**Bengalla Mine Continuation Project (SSD 5170)  
Response to exhibition of Environmental Assessment**

Comment by NSW Office of Water

**Bengalla Mine Continuation Project (SSD 5170)**  
**Response to exhibition of EIS**  
**Additional comments by NSW Office of Water (NOW)**

Figure 10.1 Conceptual proposed re-established Dry Creek alignment

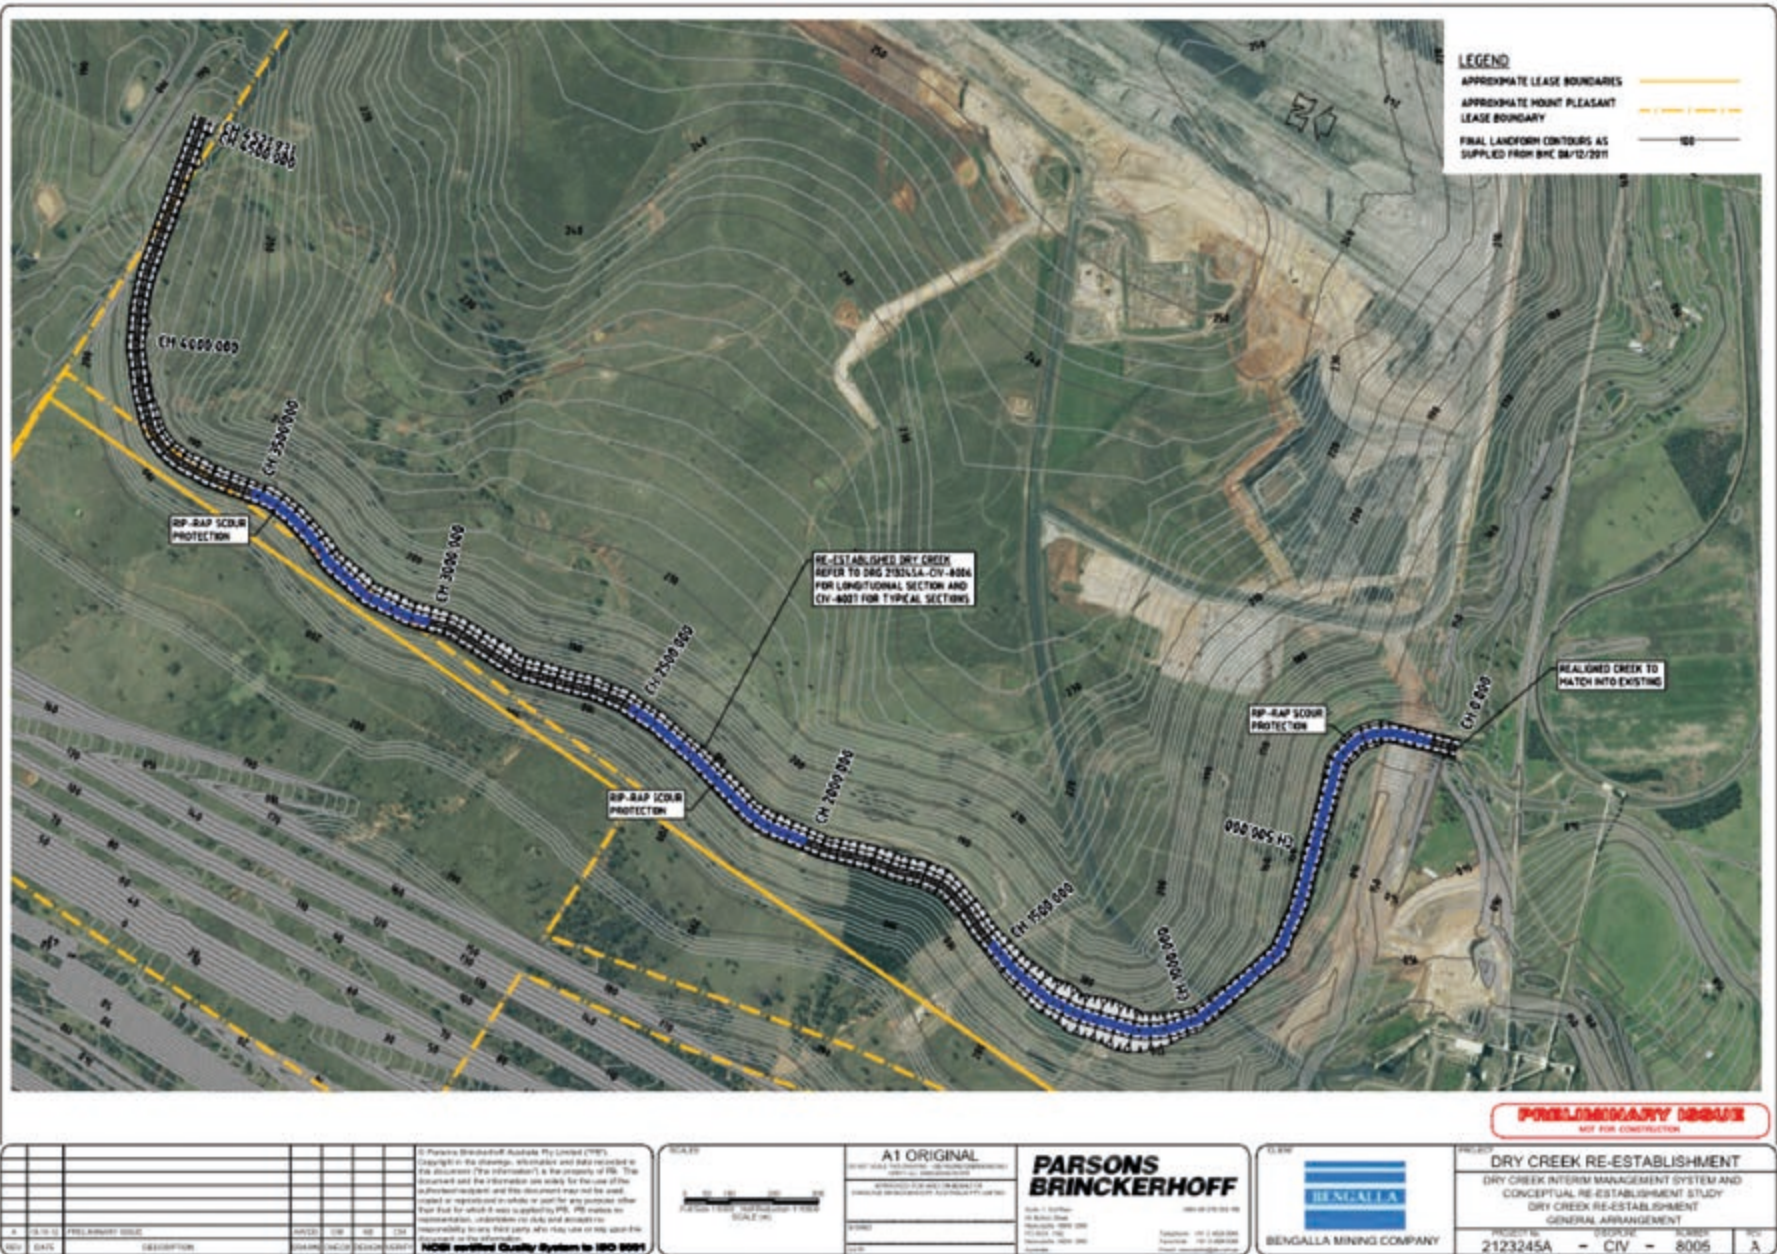
- (i) The diversion of Dry Creek will result in the loss of inflow into the Hunter River and consequently a loss of recharge into the Hunter Alluvial aquifer down gradient from the project site. The loss of catchment area (ie. including Dry Creek) from mining will result in reduced flow which is equivalent to 0.5% flow volume at Denman. In the EIS, 'this is considered negligible'. However, the EIS statement needs to clarify that 'it is negligible' under average rainfall condition but may be a significant loss during drought or extreme drought. Contingent water supply arrangements should be investigated.

- (ii) The EIS indicates that the mining company hold sufficient water access licences to account for water taken from water sources affected by operations. Modification to Dry Creek will result in reduction of its yield by 923 ML/y (page 182, EIS main report). Diversion of the Dry Creek may also result in partial loss of alluvial aquifer and alluvial groundwaters of the Muswellbrook Water Source. These water requirements are not included in the Table 56 of the main report.

- (iii) The loss of surface and groundwater due to mining operation within the Dry Creek Catchment need to be accounted for by holding sufficient shares of unregulated category access licences and aquifer access licences from the

2. The proponent must develop a contingency plan for drought conditions to address reduced flow into the Hunter River as a result of mining. This could be include scheduled mine water discharge (of reasonable quality) or redirecting runoff discharge directly into the Hunter River to provide recharge and maintain a healthy river environment. If mine water discharge is an option to be taken by the mine, then the mine water salinity levels will need to be reviewed and approved by OEH in consultation with NOW.
